Application number 2024/61/90058/W Penistone Road/, Rowley Lane, Fenay Bridge, Huddersfield, HD8 0JS

Green Alert in Lepton (GAIL) is recognised by the Council as a non-statutory consultee and representative of the Local Community on matters relating to the Local Plan.

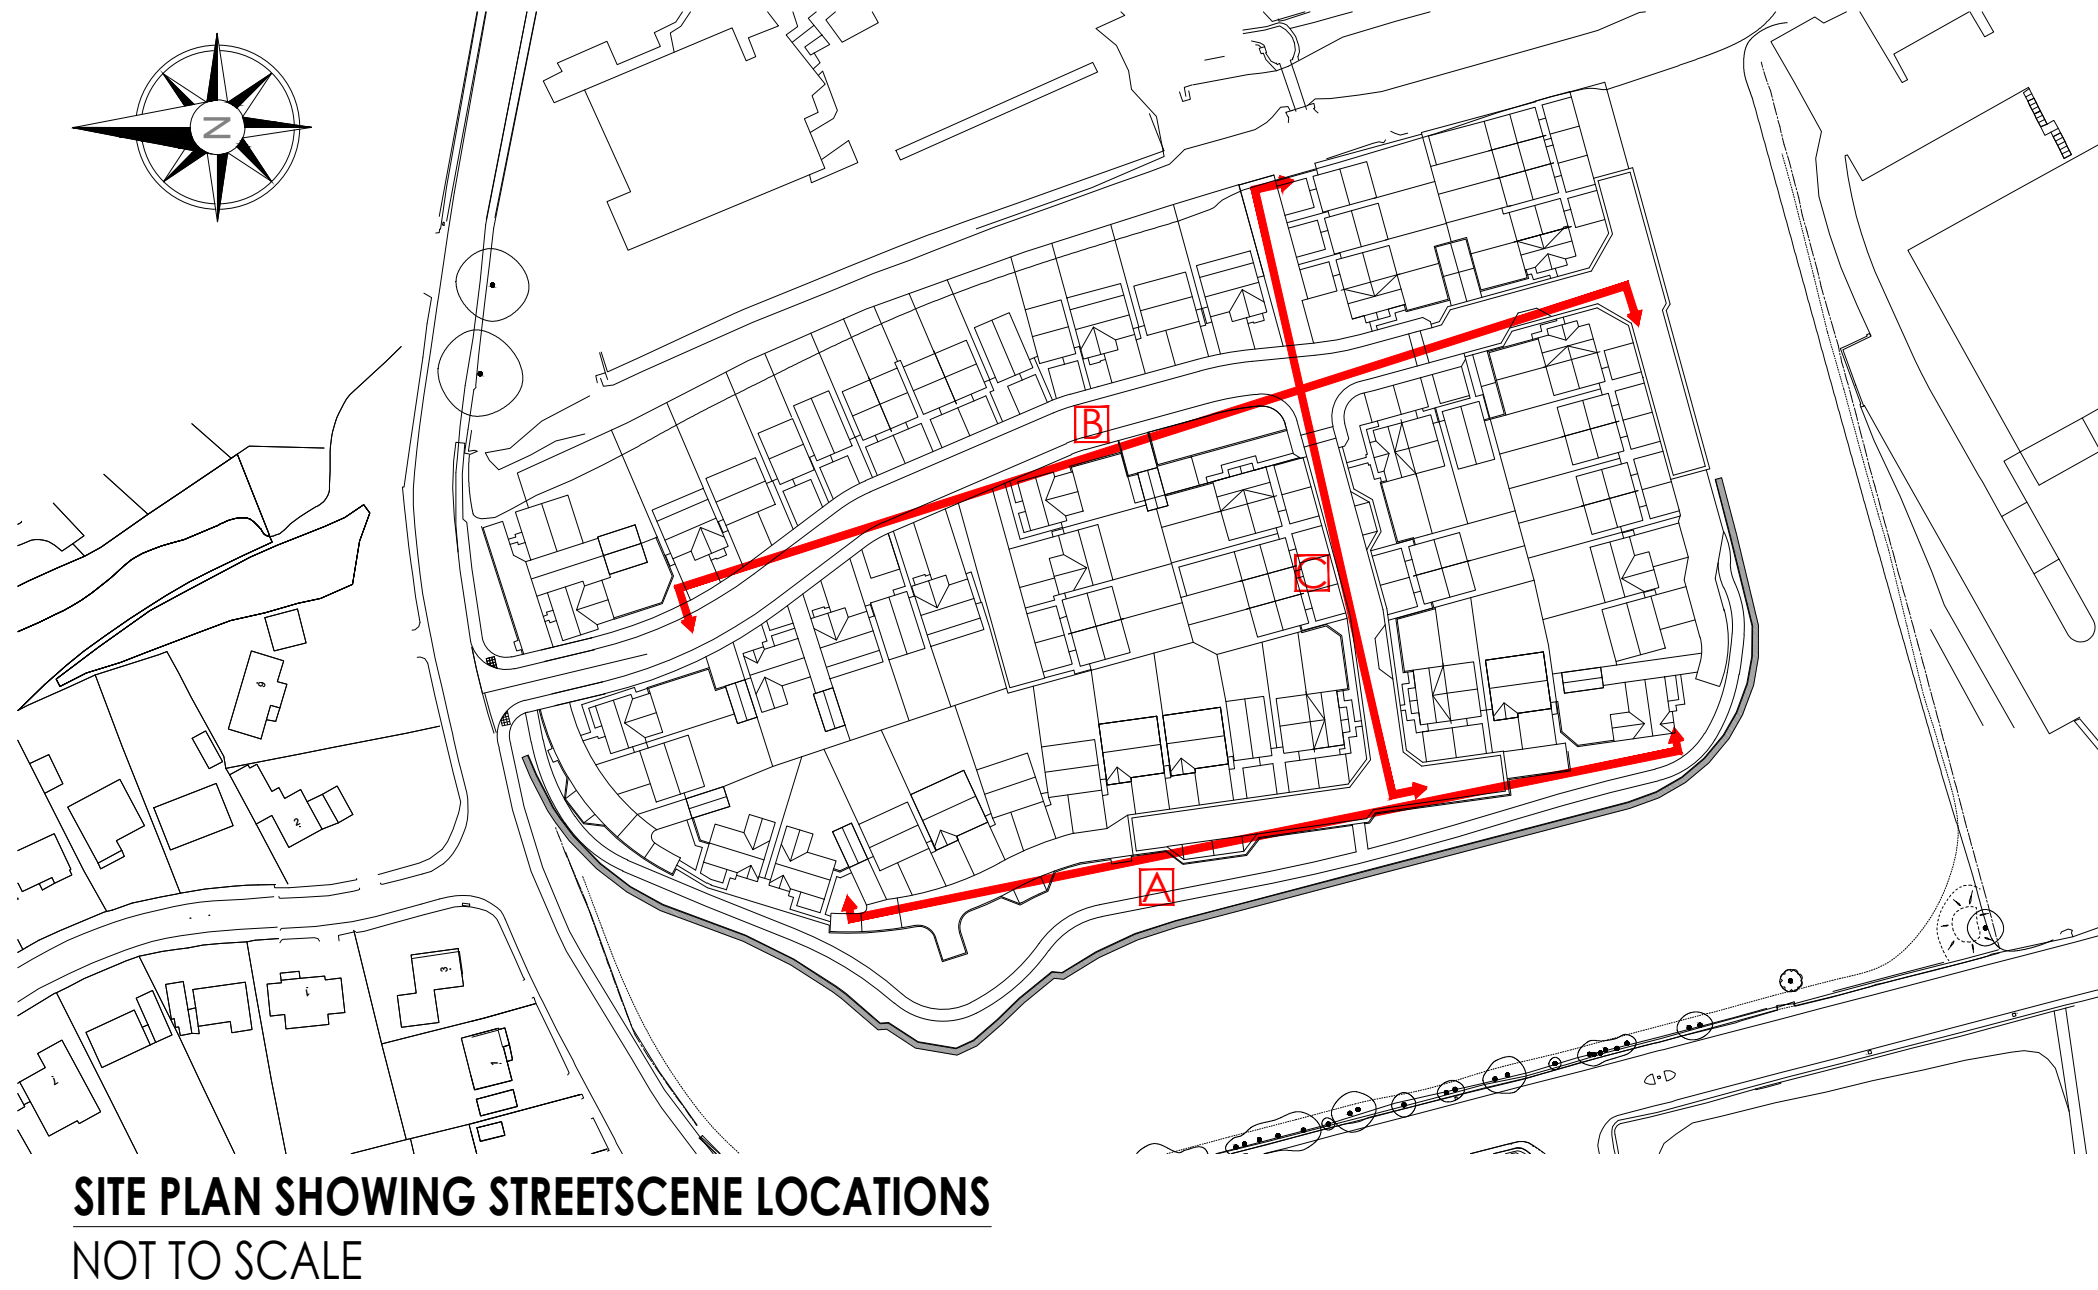
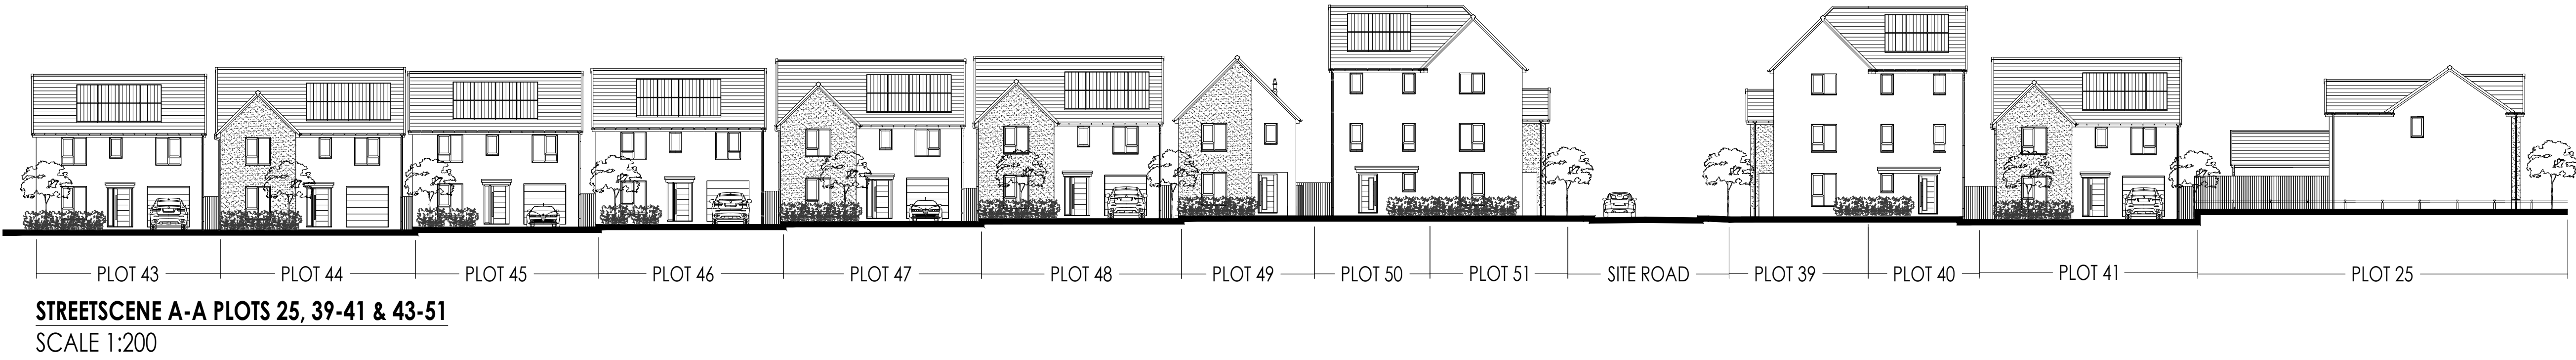
The general design and layout of this site can at the best be described as uninspiring and boring, lacking in imagination and design flair.

At a very minimum the applicant should be required to at least to use natural stone for the frontages to better blend in with surrounding properties.

To surround the frontage of the development with an 1100mm fence line will give the development the look and feel of a compound and it not recommended.
